STATE OF NORTH CAROLINA  
DEPARTMENT OF TRANSPORTATION

Subject: Revised Application for USACE General Permit 31 and Section 401 Water Quality Certification, for the proposed improvement of NC 211 from west of NC 906 (Midway Rd.) to east of NC 87 in Brunswick County. TIP No. R-5021. WBS 41582.1.1.

Reference: NCDOT permit application dated July 23, 2018.

PROJECT REFERENCE NO. R-5021	SHEET NO. 5
ROADWAY DESIGN ENGINEER <i>[Signature]</i>	HYDRAULICS ENGINEER <i>[Signature]</i>
<p>DOCUMENT NOT CONSIDERED FINAL UNLESS ALL SIGNATURES COMPLETED</p>

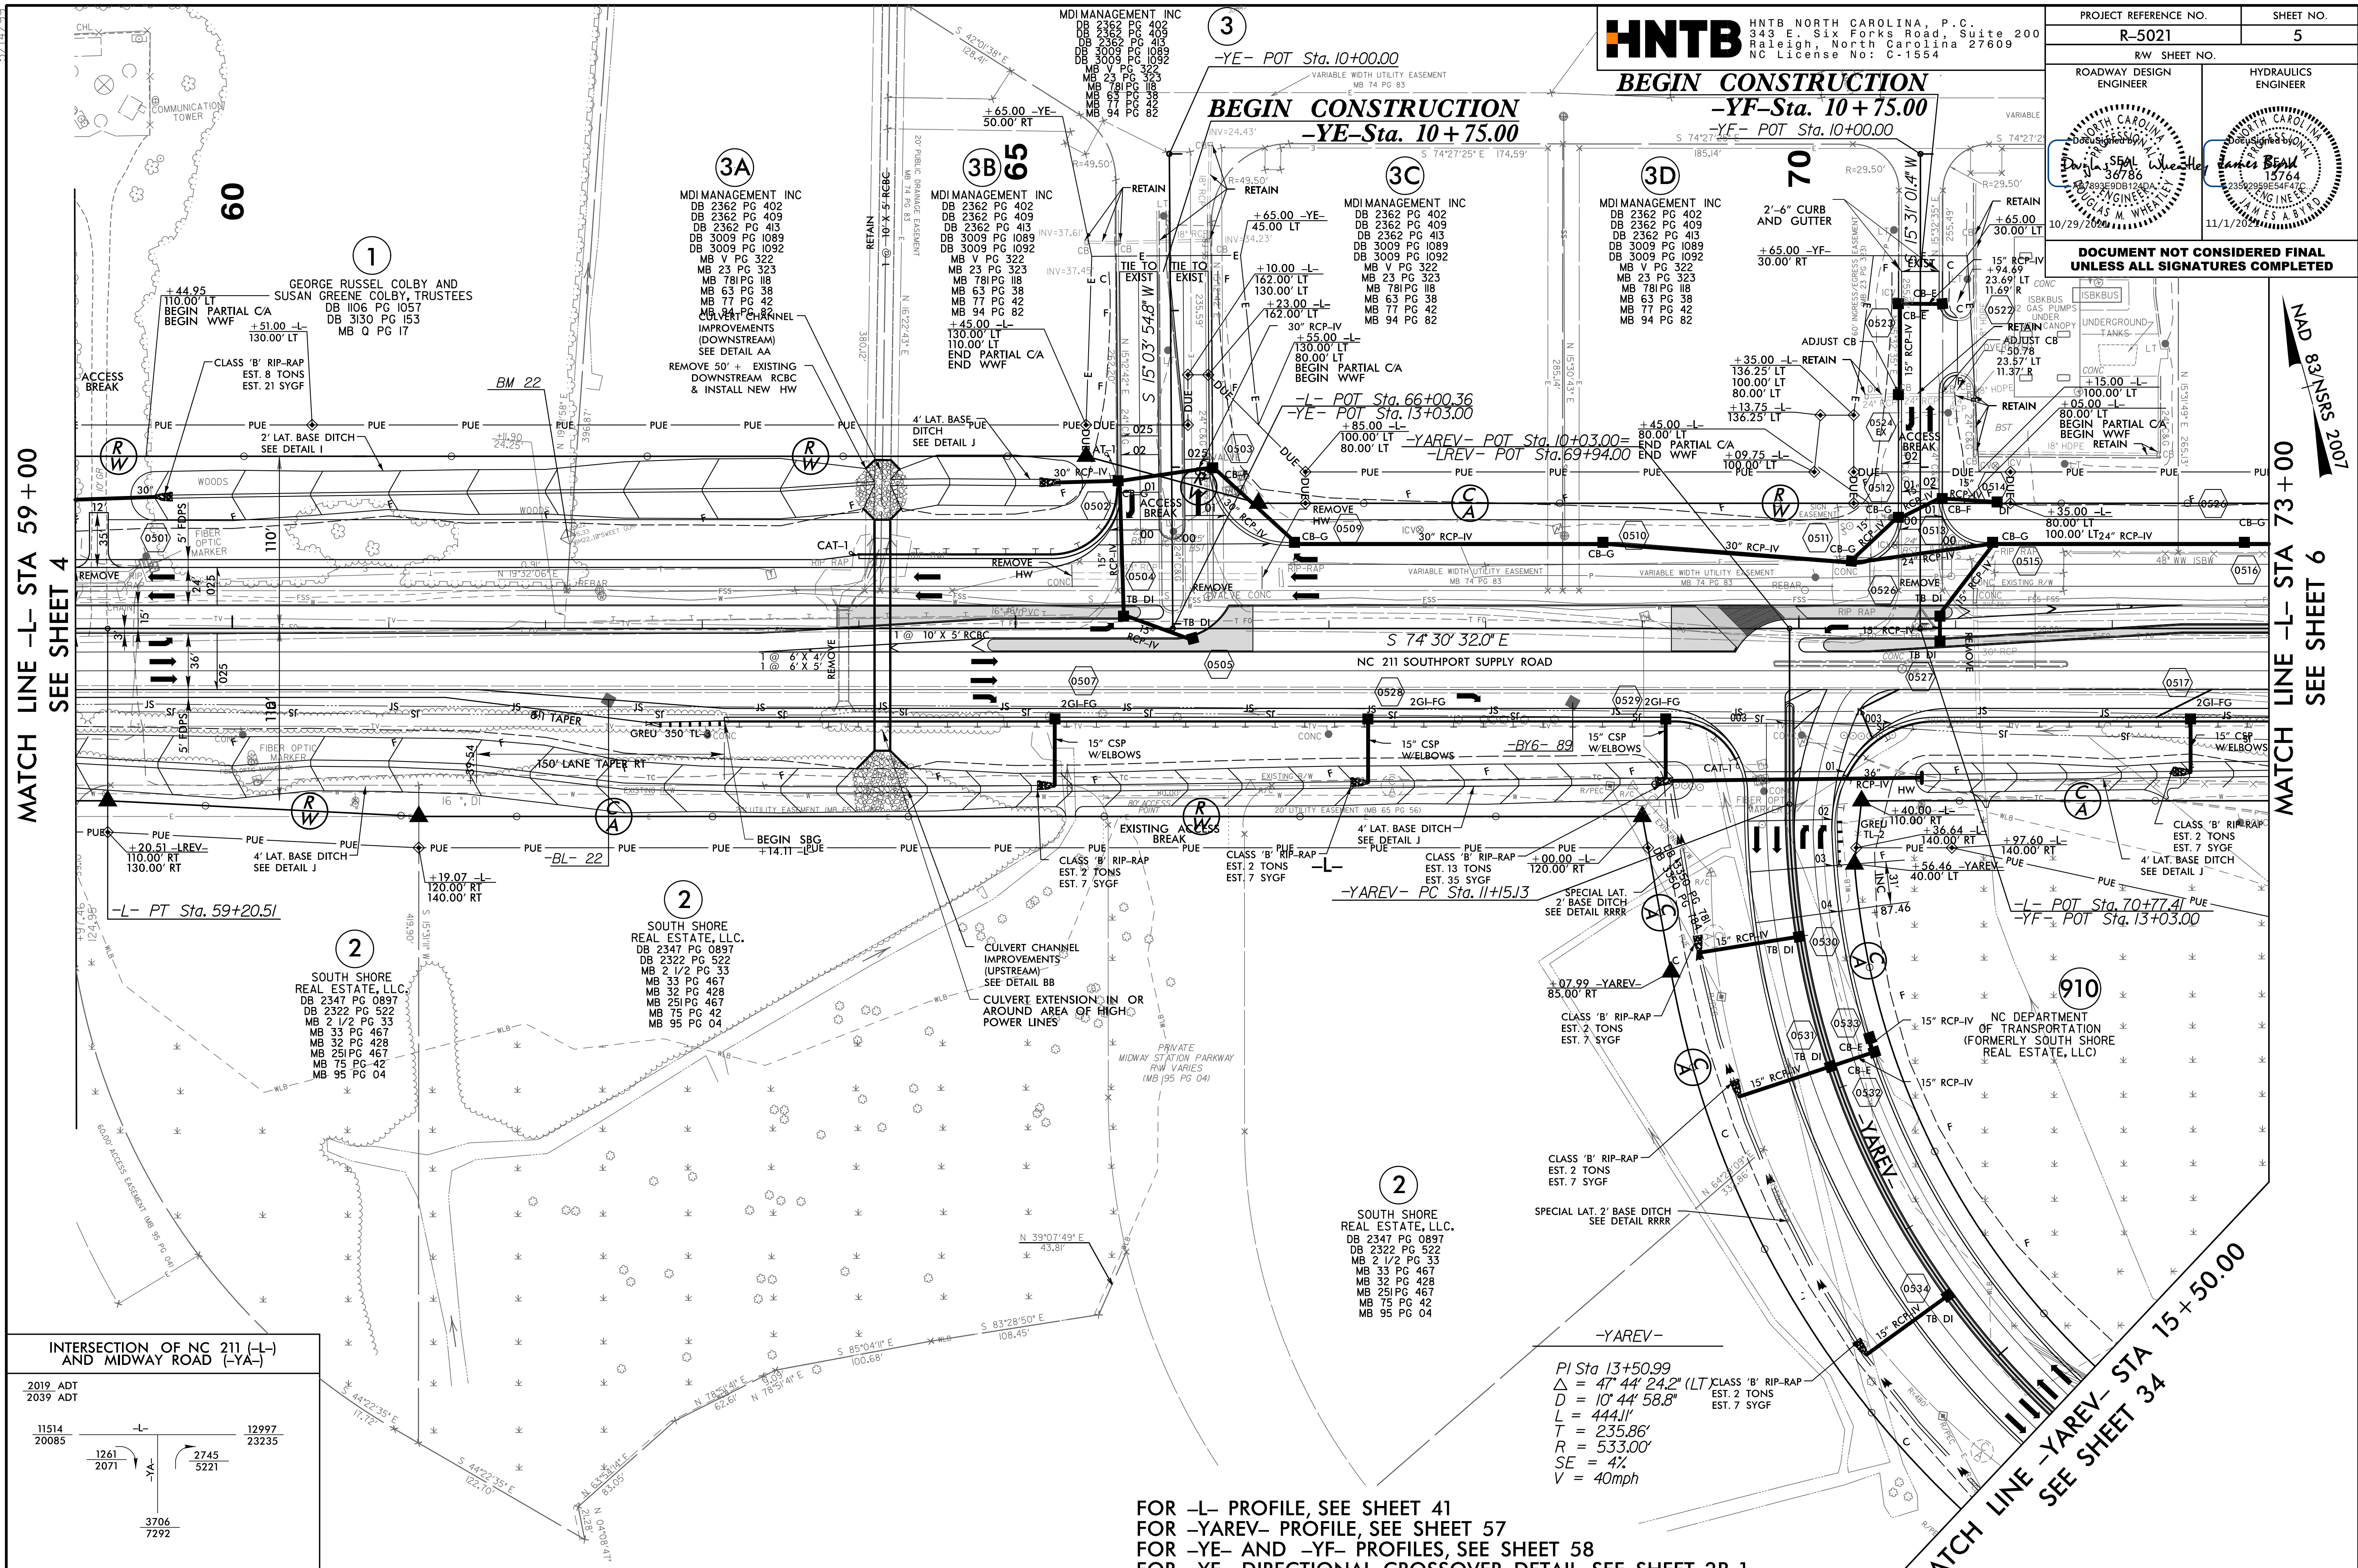
- Permit Drawing Sheets 5 and 6, Site 2: Detail BBBB for Sta. 64+15 to 71+26 RT (encompasses Site 2) has been added to Sheets 5 and 6 to match the proposed ditch depth shown on cross section 70+50.00 (Sheet 7).

- Permit Drawing Sheets 5 and 6, Site 3: A 2 ft. ditch was not evaluated for drainage effect at this site. Therefore, an additional 0.11 acre of wetland excavation impact is now shown on the drawing and in the impact summary to account for the drainage effect from ditching.
